Thank you for your letter dated 9 November 2023 notifying me of the proposed erection of a single storey extension with roof terrace above, external alterations and extension of existing garage at 8 Boulder Gate, Marsden (application 2023/93205).

Having viewed the application, including plans and documentation on the Kirklees planning portal, I would like to object to the single storey extension with roof terrace and patio doors above – I do not have any objections to the internal alterations and the extension of the existing garage.

Drawing Title:
General Arrangement
as Proposed

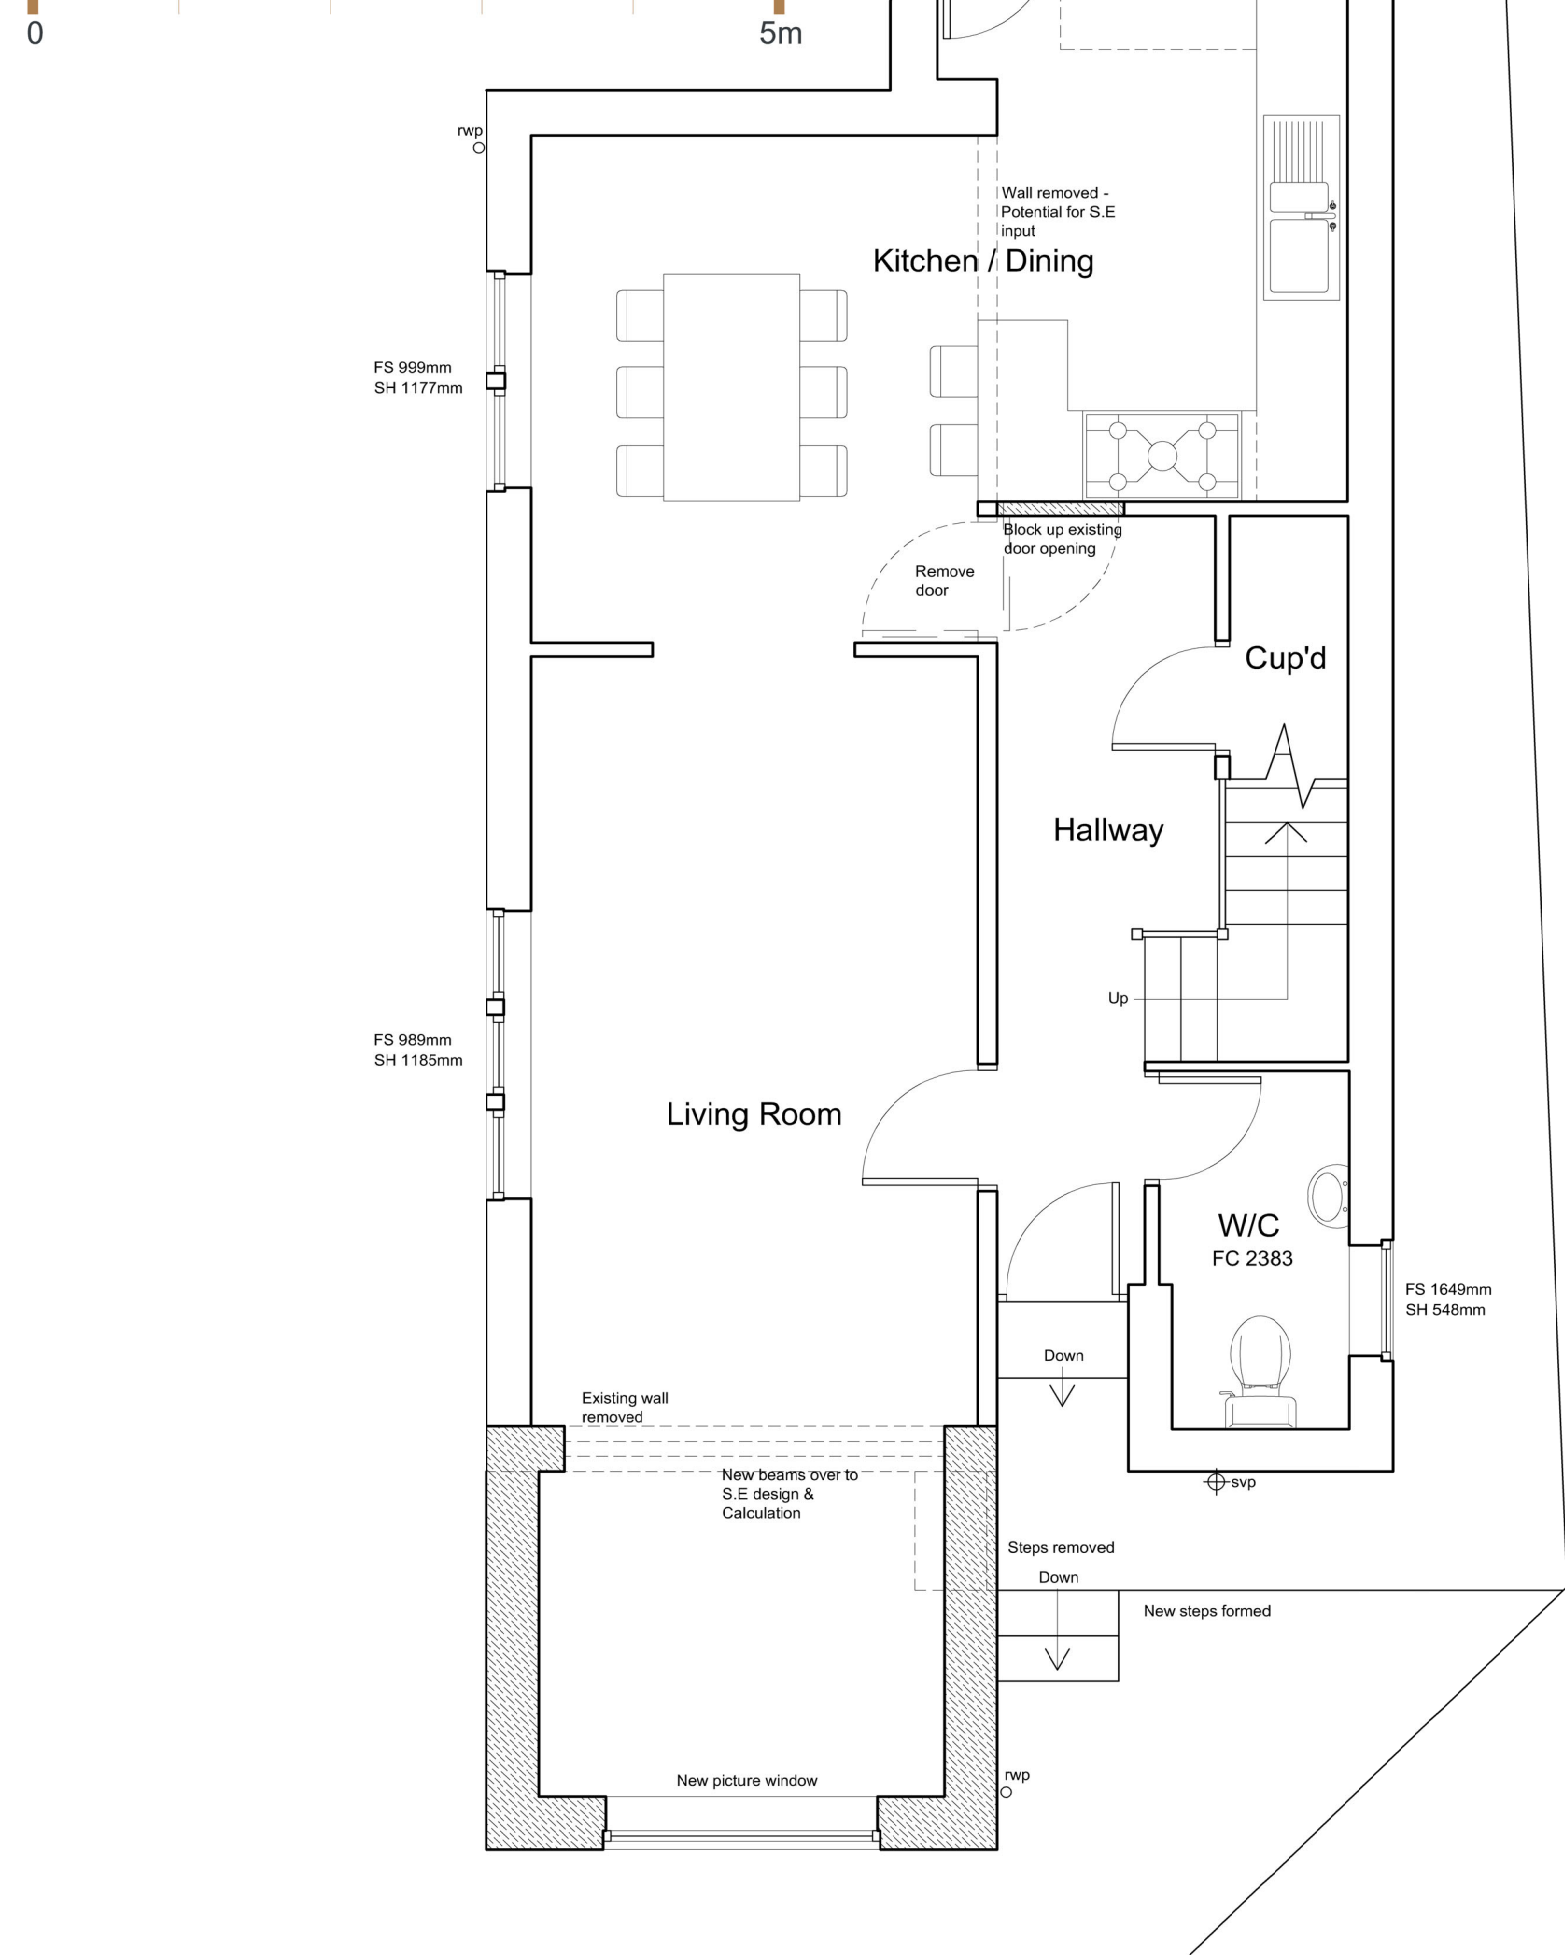
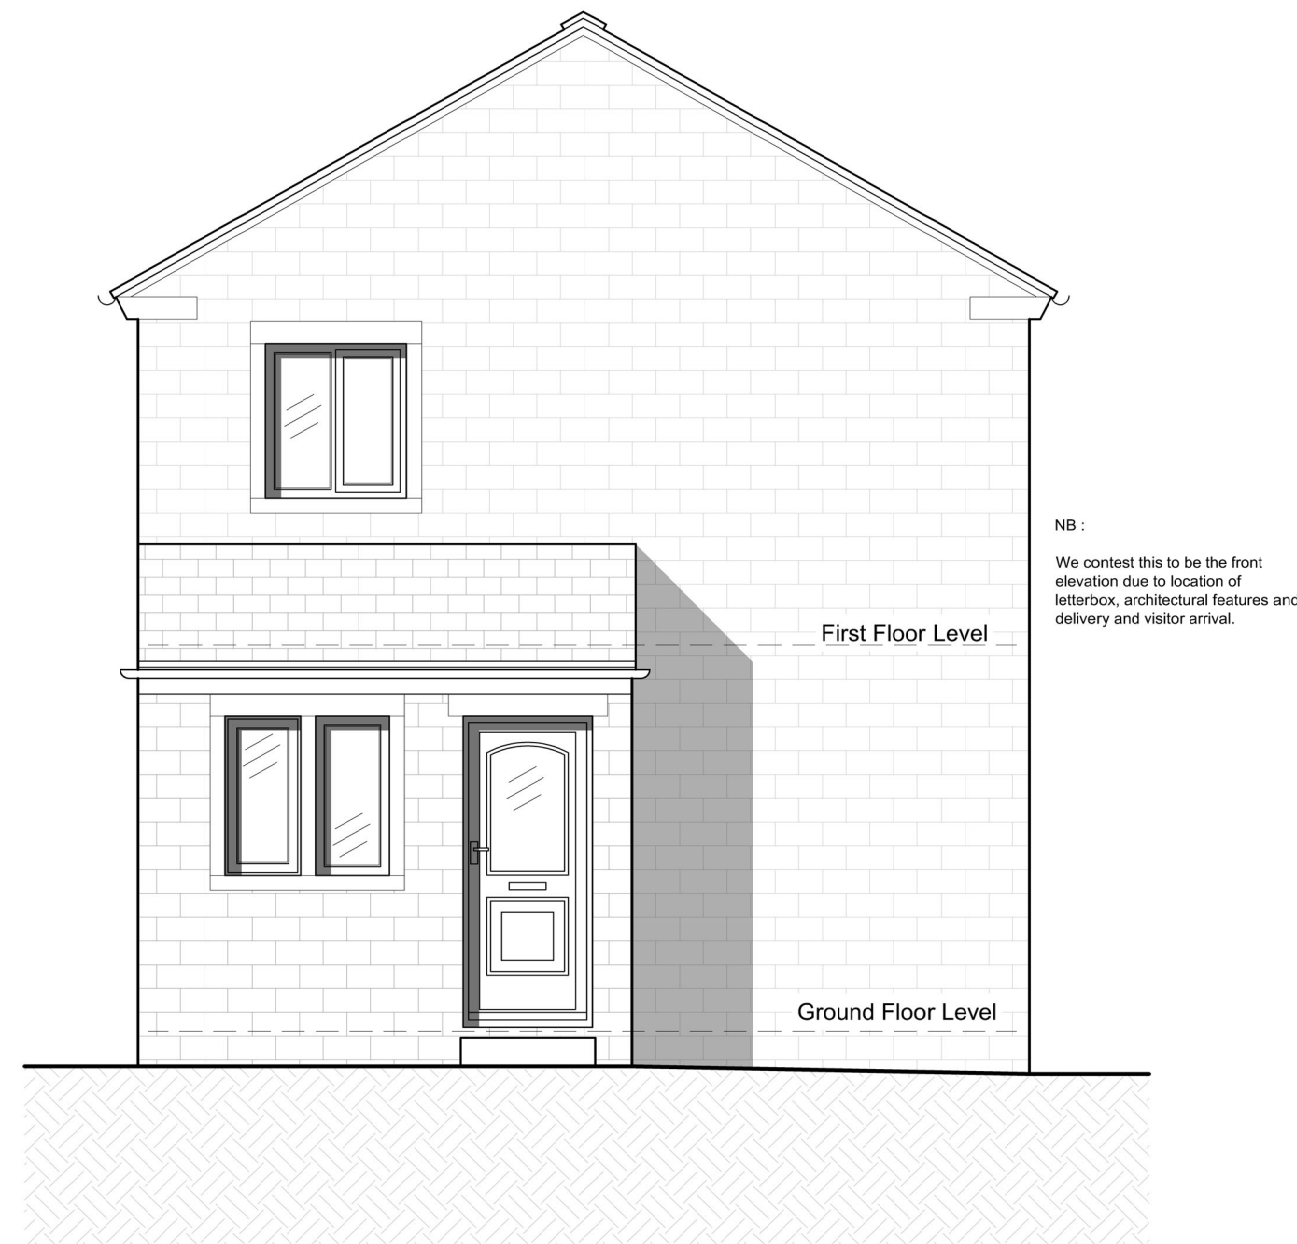
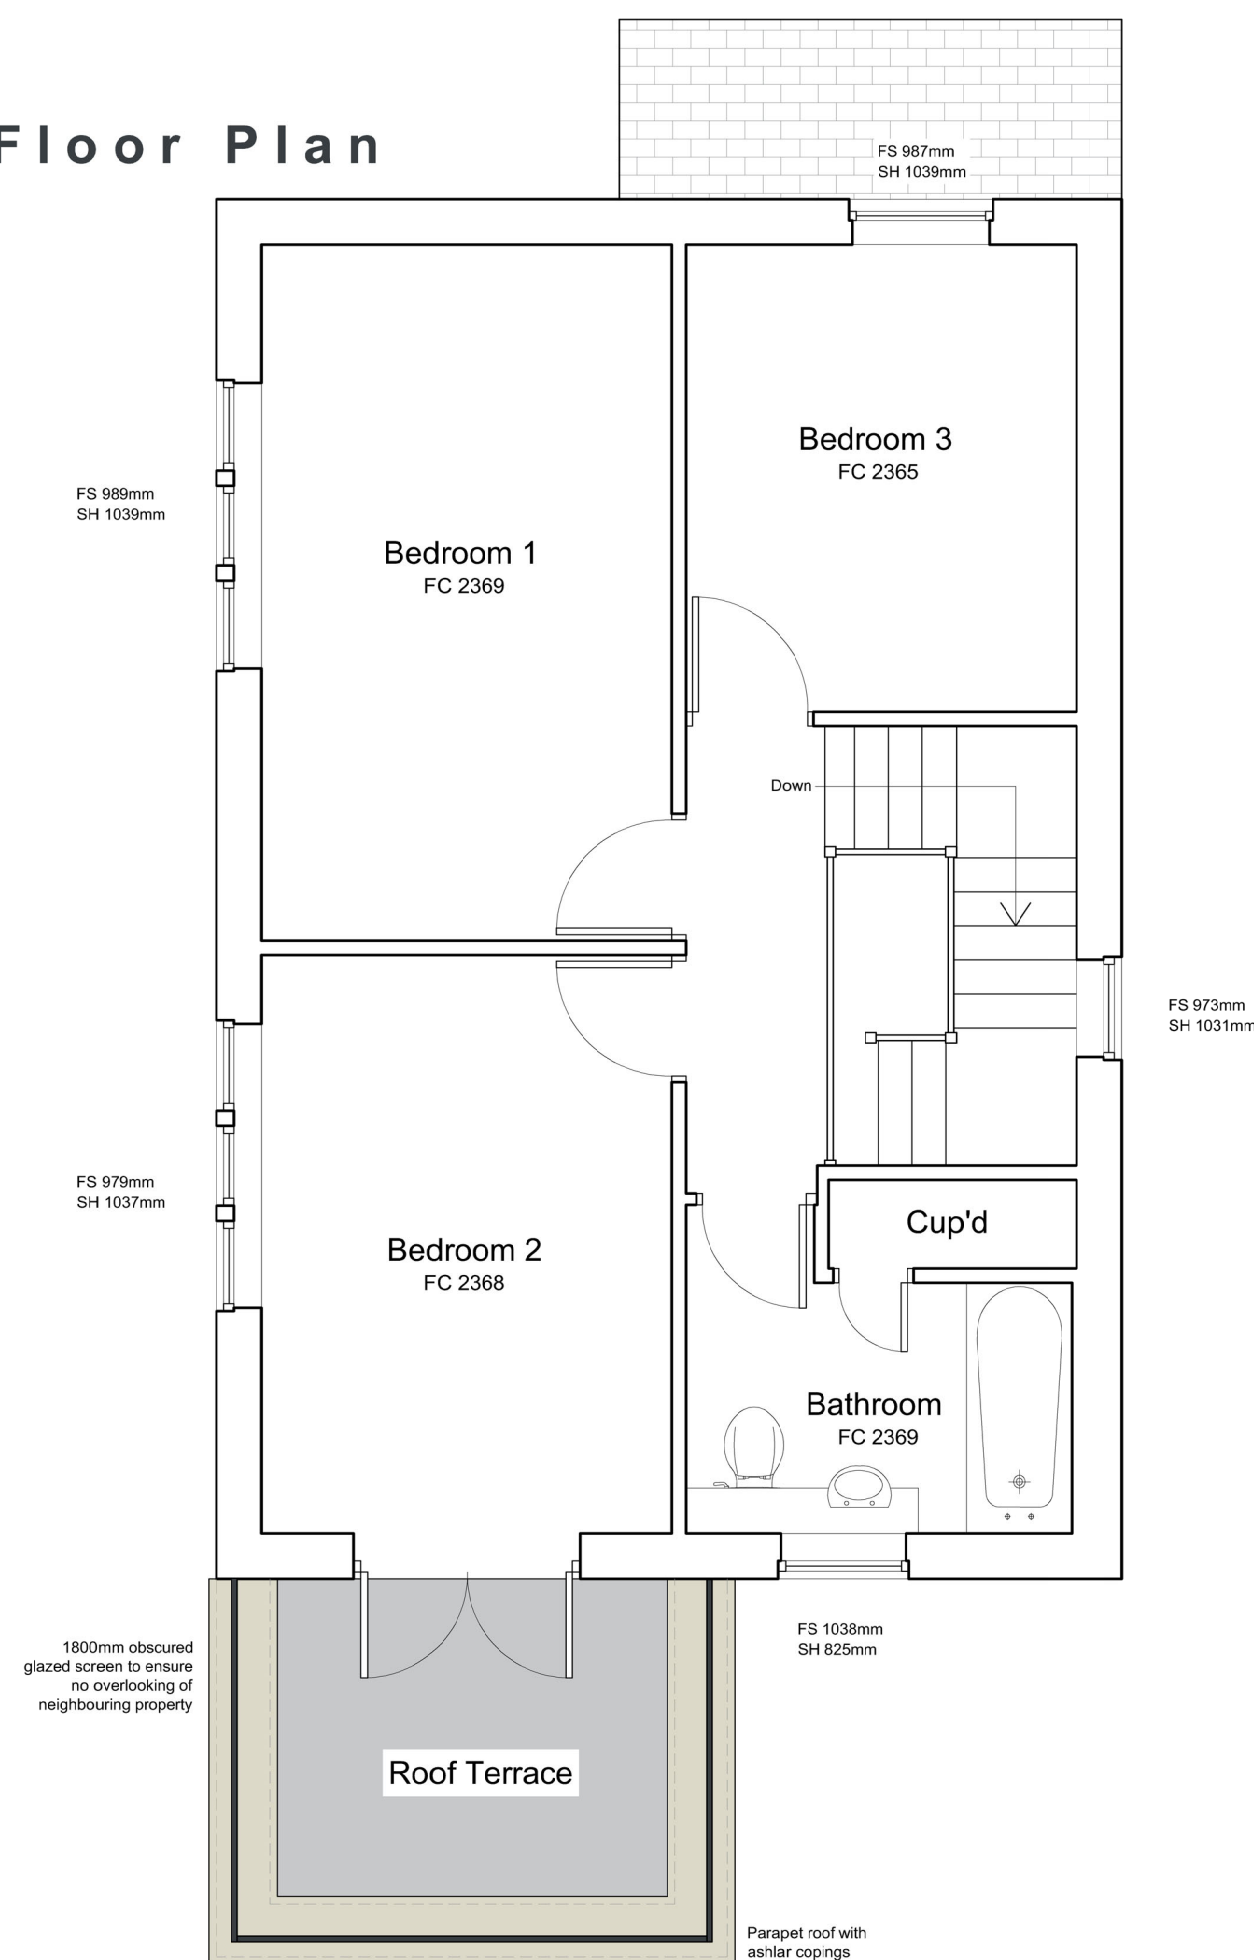
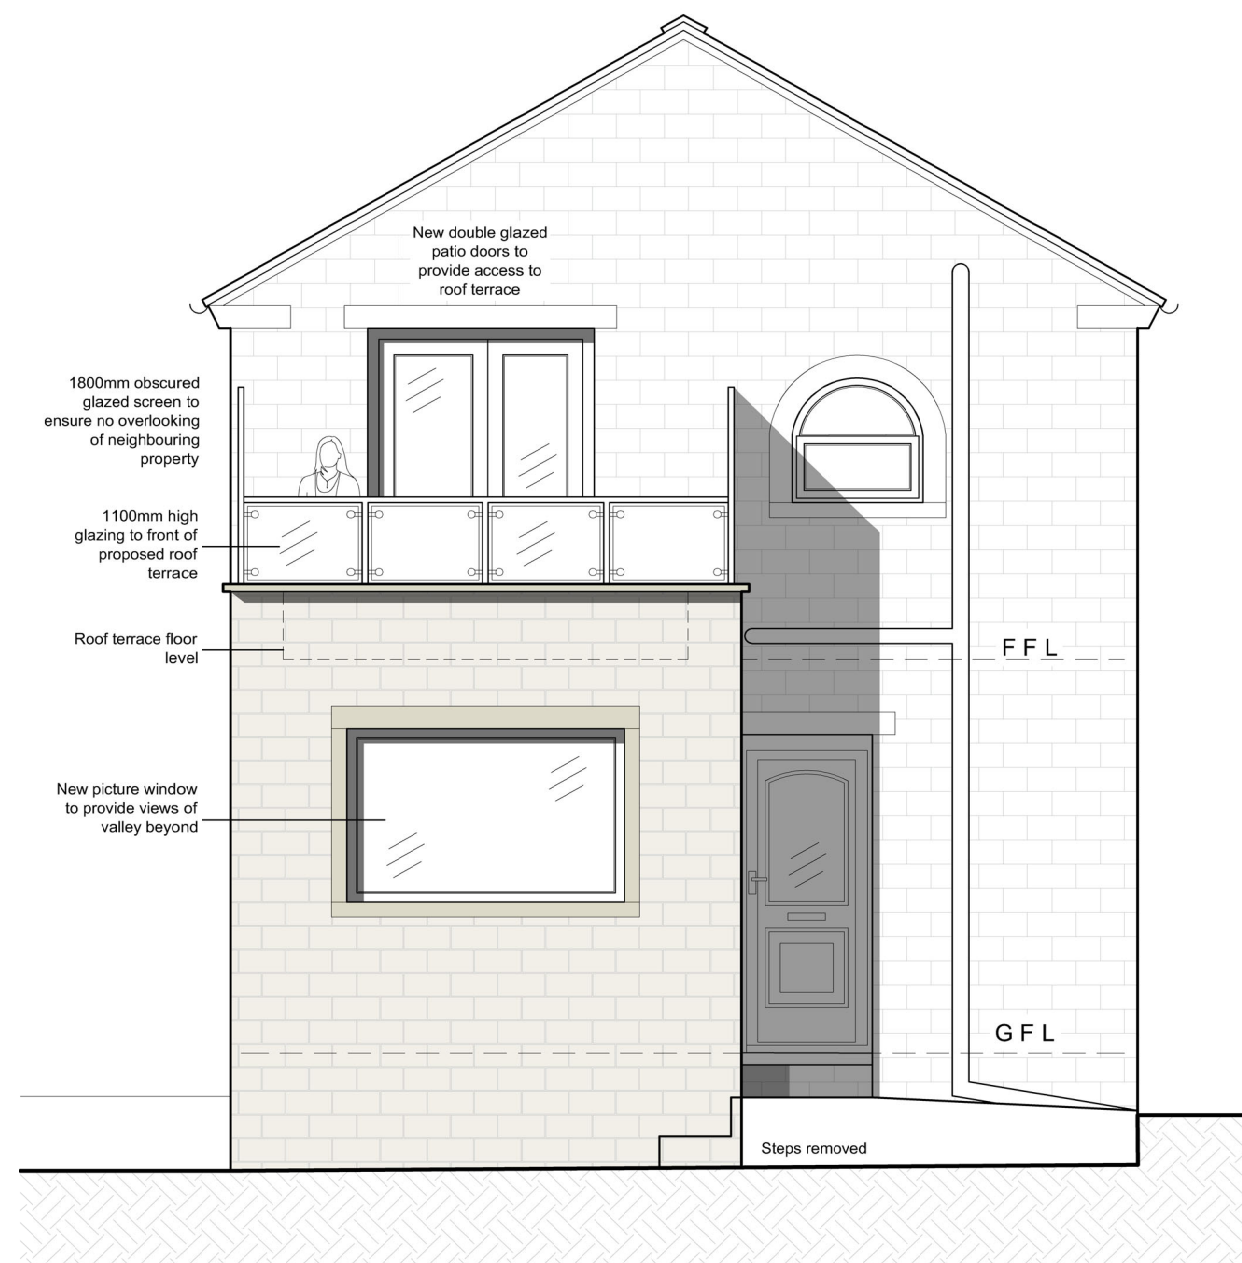
- b. There are no dimensions on the proposed extension – if shown with the correct orientation it appears that the extension will be right up to my boundary overlooking my bungalow and garden through the large picture window, roof terrace and patio doors.

- e. An 1800mm high obscured glazed screen is mentioned, I am unclear if this is 1800mm from the floor or top of the parapet wall.

- a. As I understand it, when shown with the correct orientation of 8 Boulder Gate, the proposal is to build a single storey extension up to my boundary with a large picture window overlooking my bungalow and garden. It is proposed to have a roof terrace above with parapet wall surround with ashlar copings and glazed screen. The proposal also includes for a new opening at first floor level with double patio doors again overlooking my property. The current garden steps are to be removed.

- b. Due to the steeply sloping ground away from my property, the ground floor of the 8 Boulder Gate extension, will be approximately 3 metres above the level of my drive at the front of their extension. An average person of 1.6 metres looking out of the ground floor picture window would be some 4.6 metres above my drive and on the roof terrace this same person would be some 7.2 metres above my drive.

- c. Similarly with my front garden – an average person of 1.6 metres looking out of the ground floor picture window would be some 3.7 metres above my garden and on the roof terrace this same person would be some 6.3 metres above my garden.
